Re: *Montgomery / Wyoming Restaurant Project*

Attached is a copy of the FINAL Traffic Impact Study for the referenced land development project for your approval. The Study has been revised to address Jeanne Wolfenbarger's comments in her e-mail dated July 21, 2015 as follows:

From: Wolfenbarger, Jeanne <jwolfenbarger@cabq.gov>
Sent: Tuesday, July 21, 2015 9:29 AM
To: 'Terry O. Brown'
Cc: Michel, Racquel M.
Subject: Comments on "Wyoming/Montgomery Restaurants" Traffic Impact Study

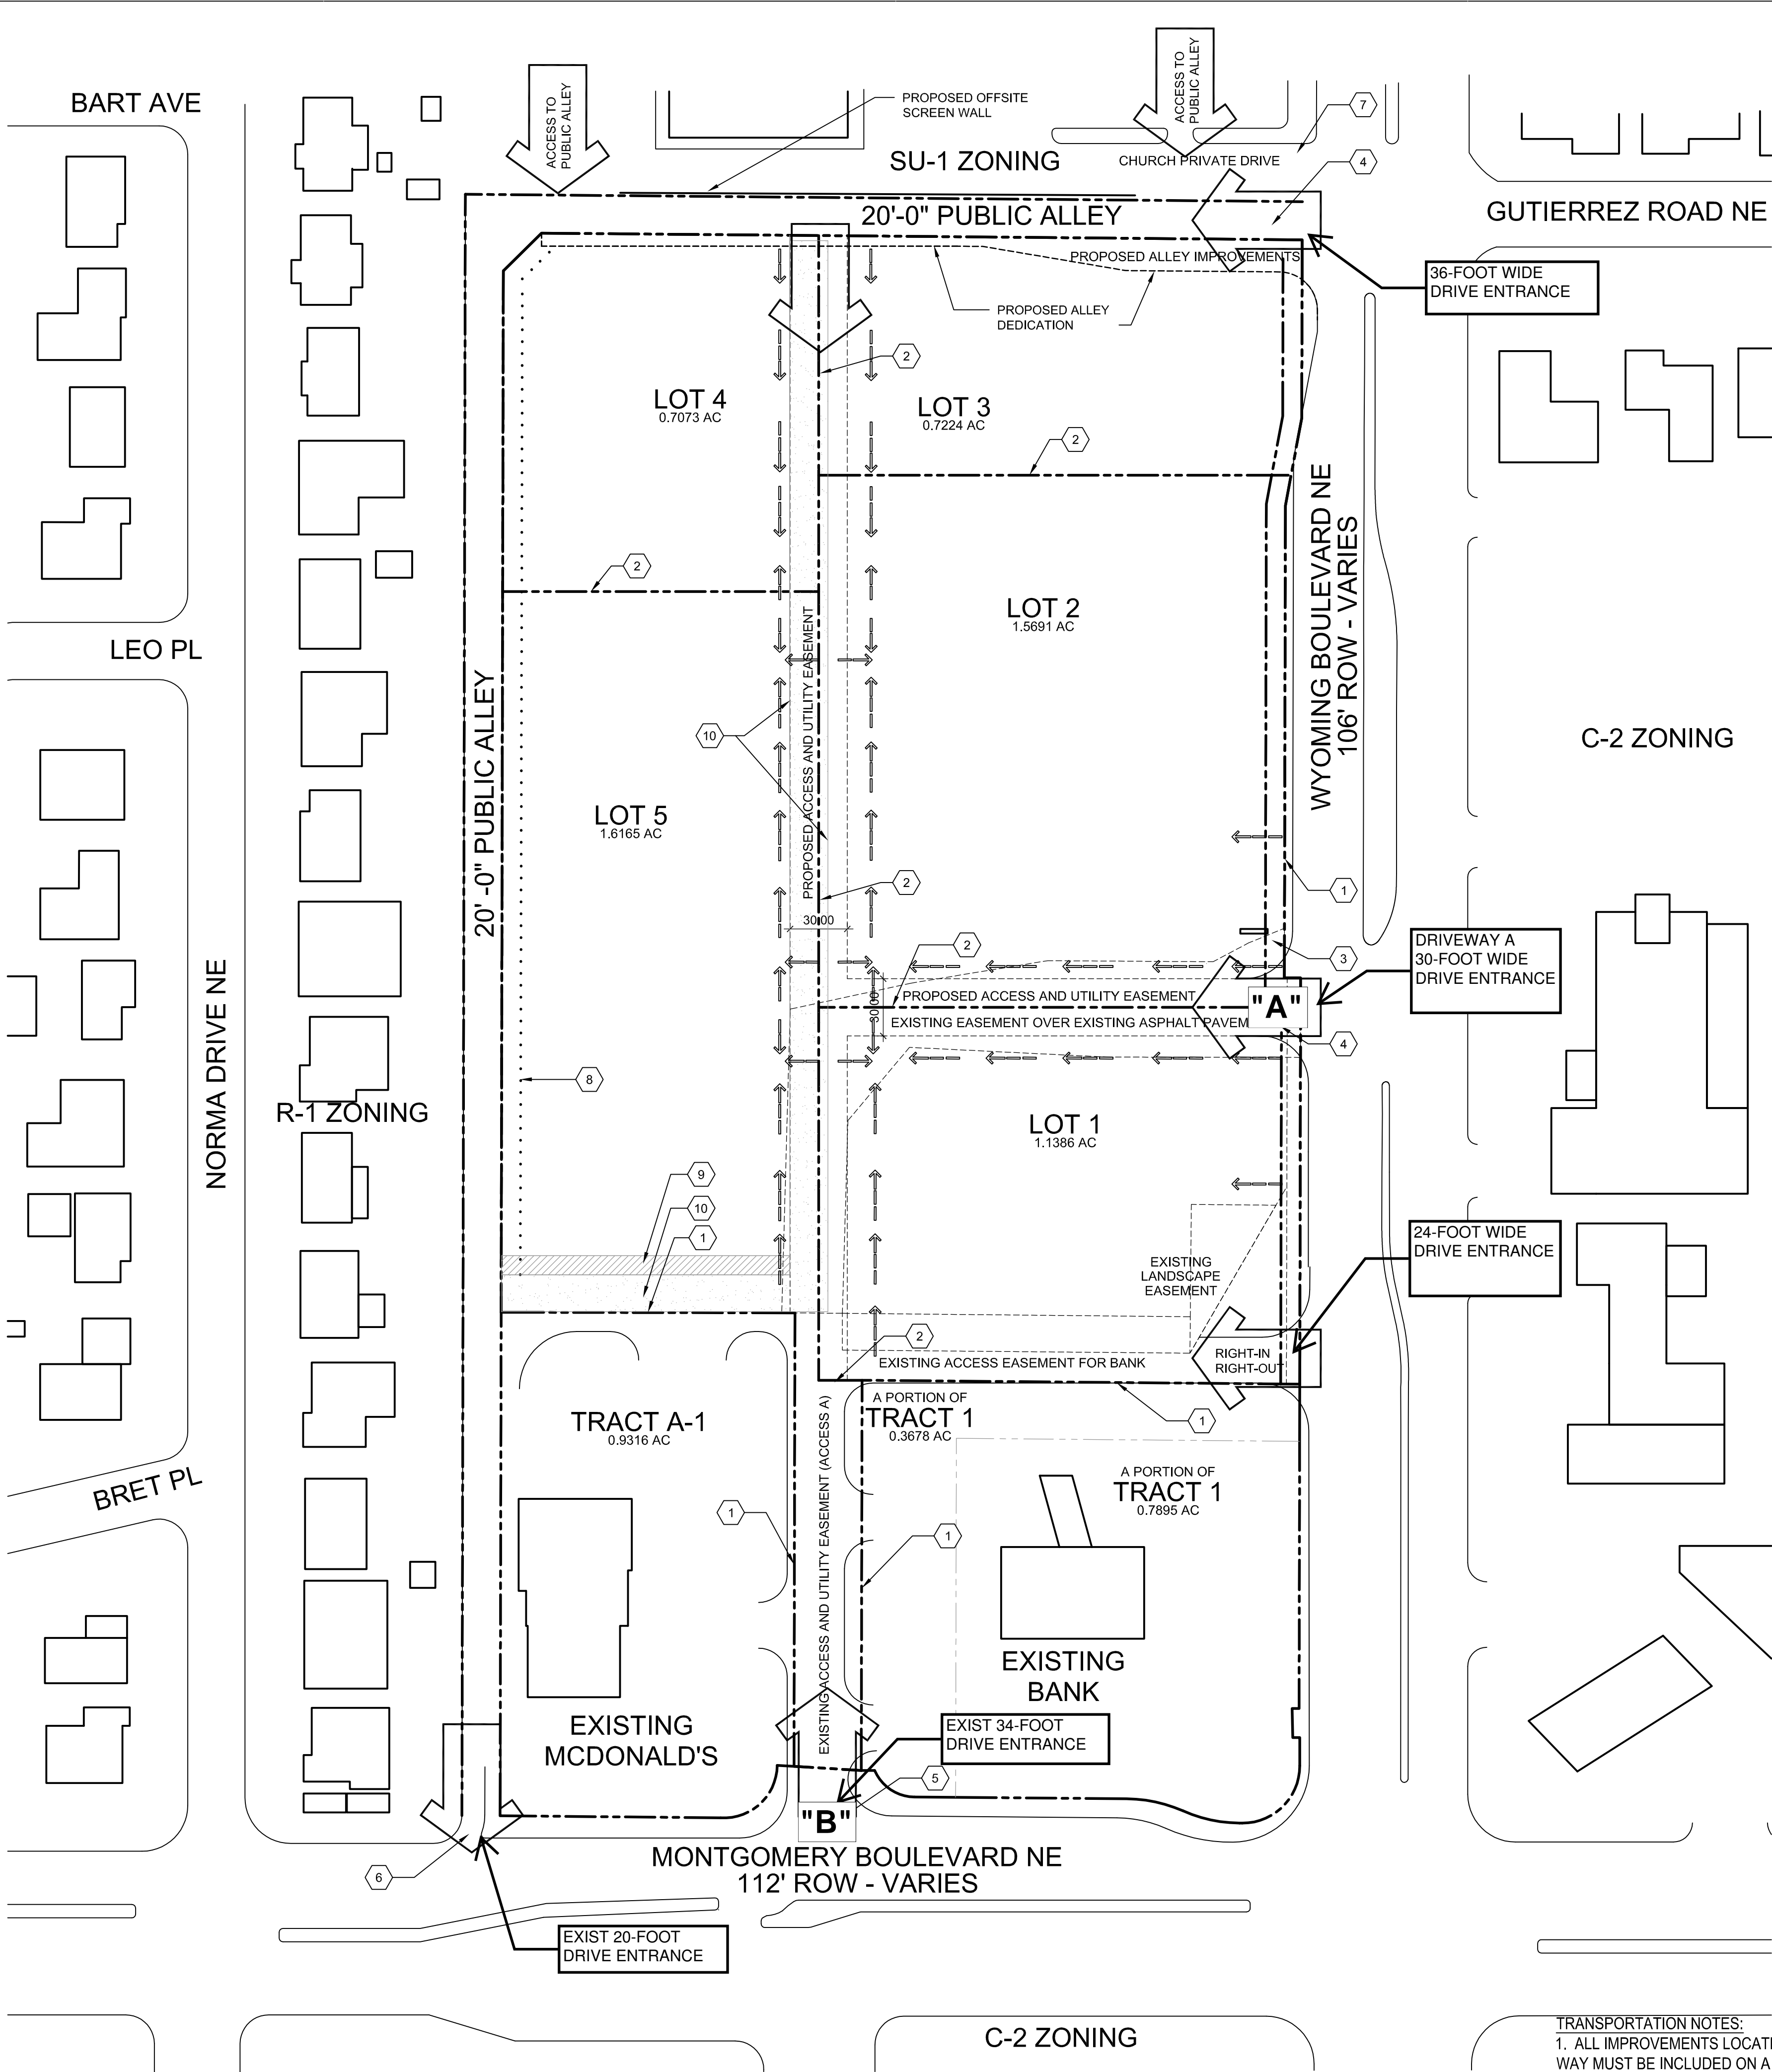
- A. On the site plan on Page A-2, label all improvements including all recommended lanes, label driveways "A" and "B" and Gutierrez. Show any pertinent access easements. Show all property lines and the property lines surrounding the access out to Montgomery Boulevard. Show the widths of all access points.

- A. On the site plan on Page A-2, label all improvements including all recommended lanes, label driveways "A" and "B" and Gutierrez. Show any pertinent access easements. Show all property lines and the property lines surrounding the access out to Montgomery Boulevard. Show the widths of all access points.

RESPONSE: The new site plan shows additional data as requested.
- B. Provide copy of any access agreements. Access agreement with the neighboring church will be required prior to approval with current traffic scheme.
